Your ref: TR010037
Our ref: JEC/JB51570
DD: [REDACTED]
E: [REDACTED]@bidwells.co.uk
Date: 3 February 2022

THE TRUSTEES OF THE MACKINTOSH TRUST – APPLICATION BY HIGHWAYS ENGLAND (NOW NATIONAL HIGHWAYS) FOR AN ORDER GRANTING DEVELOPMENT CONSENT FOR THE A47-A11 THICKTHORN JUNCTION PROJECT

DRAWING TITLE  
**GENERAL ARRANGEMENT PLANS  
REGULATION 5(2)(o)  
SHEET 3 OF 7**

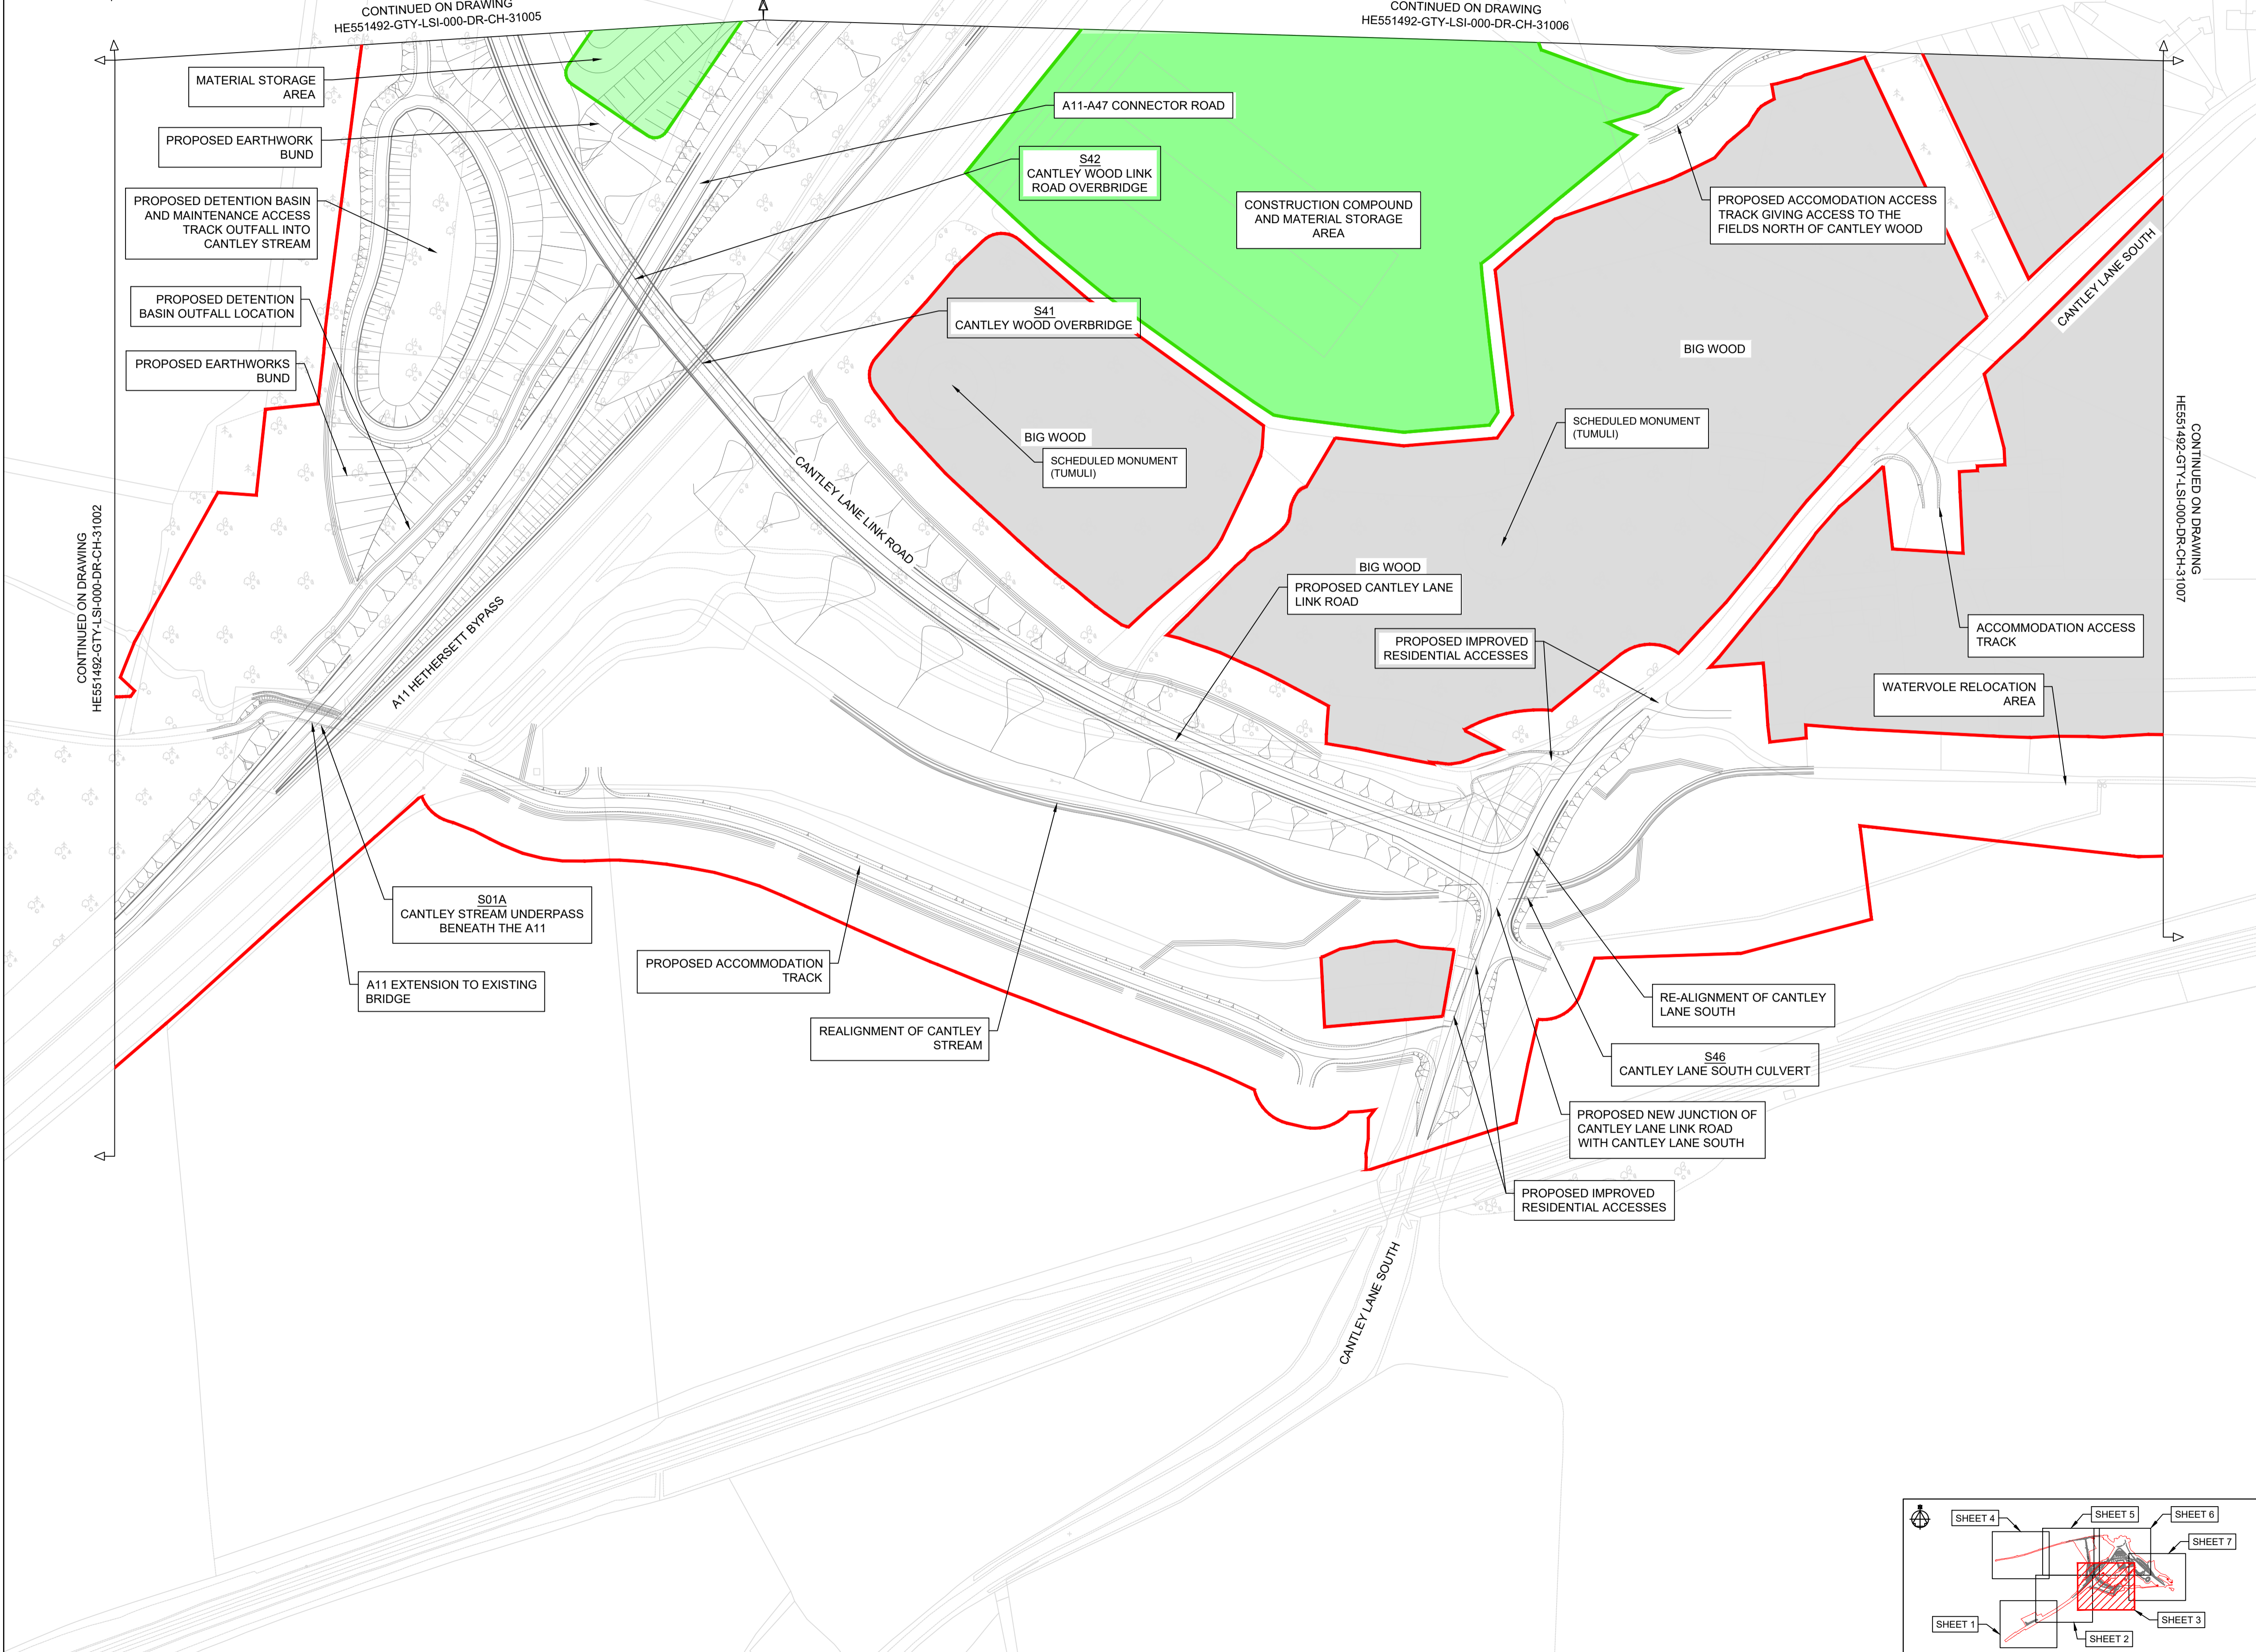
6. Of fundamental importance to my client is the specification and future ownership and access rights over the proposed accommodation track, shown on drawings HE551492-GTY-LSI-000-DR-CH-31003 and HE551492-GTY-LSI-000-DR-CH-31006, enclosed. My client is losing their existing access to the fields north of Cantley Wood as a consequence of this project, this being an access and track over which they have complete control and security, and across which two vehicles can pass side by side. We realise there may be no alternative route for the proposed accommodation track than the long one proposed and that Highways England will need to retain some rights of access and maintenance over it in the future. That being accepted, where possible my client should not be left in a worse position after this project than before it and thus should be granted ownership of the new track without any restrictions on their use of it, and it should be the case that the new

route is properly secured and capable of accommodating two cars side by side. We await confirmation that these requirements are being facilitated.
